25 May 2012

Application No.	SSD 5003
Location	Lot 6 DP 1058047
Applicant	Health Infrastructure
Consent authority	Minister for Planning and Infrastructure
Council area	Campbelltown
Proposal	Stage 1 Development, Acute Health Services Building, Campbelltown Hospital

View from Parkside Crescent

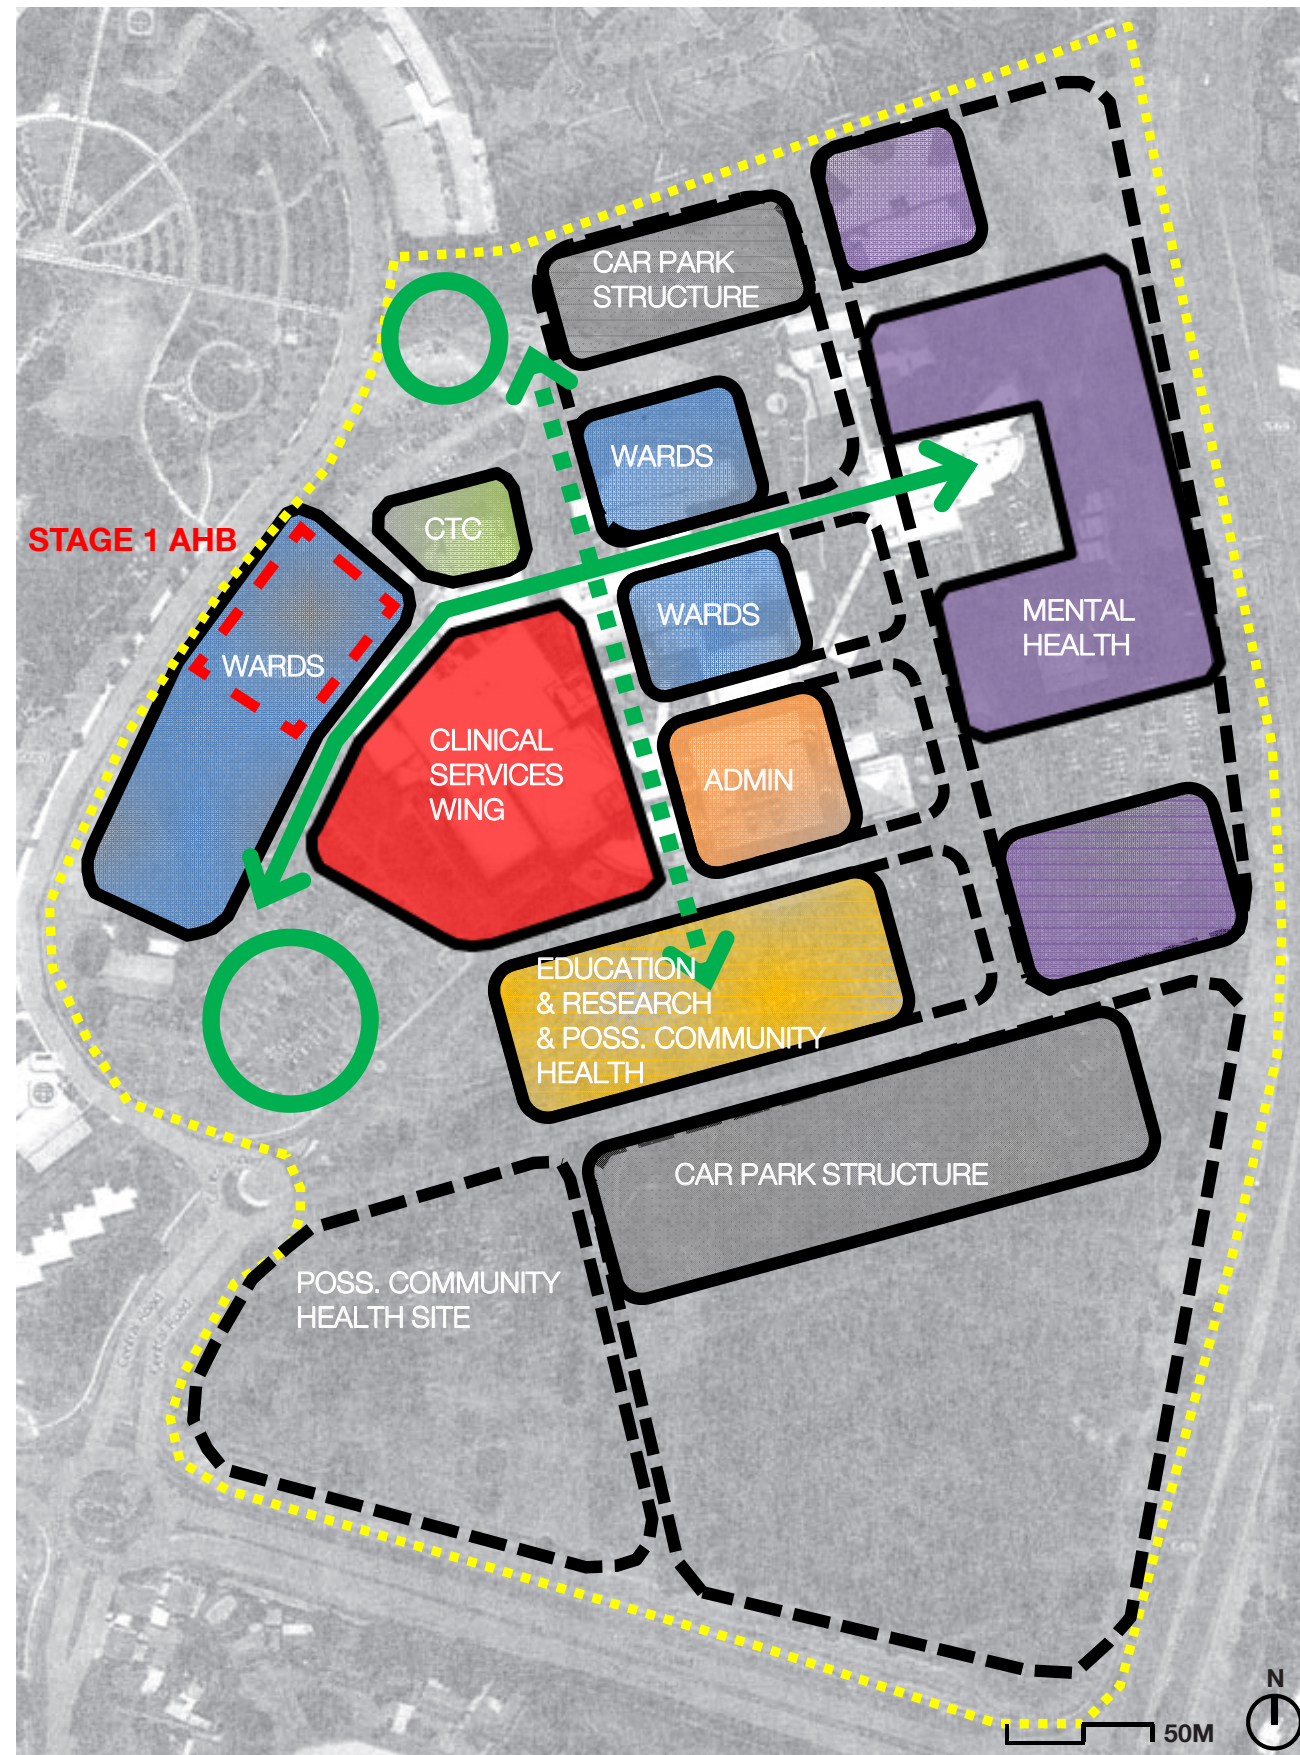
Given the location and visual prominence of the hospital site, the 'massing' and scale of the building and in particular the large areas of concrete proposed to be exposed as part of the proposed building's façade and adjacent retaining walls at street level (including that depicted on the two proposed stair towers) are of significant concern to Council. This outcome would present the building with a bland and imposing appearance with little articulation, and offer minimal visual interest as viewed from the public domain.

Further, due to the large areas of concrete proposed at street level, the development does not interact positively with the street domain and presents significant opportunity for graffiti attack. Although the ground level of the building and retaining walls would be partially screened by landscaping, the urban design outcome is not satisfactory. Landscaping should not be relied upon to screen an unsatisfactory design.

- Glazed windows or alternative architectural devices need to be provided at street level on the building's western façade.
- The protruding stair towers require improved design and architectural treatment including articulation, additional glass and/or alternative/supplementary materials and/or colours.
- The building's roof should be redesigned to achieve an improved visual interest.
- The change in ground levels between the street and the area north of the proposed hospital building requires a better solution than a large bland retaining wall. A landscaped slope or stepped landscape area must be provided to facilitate the change in ground levels.
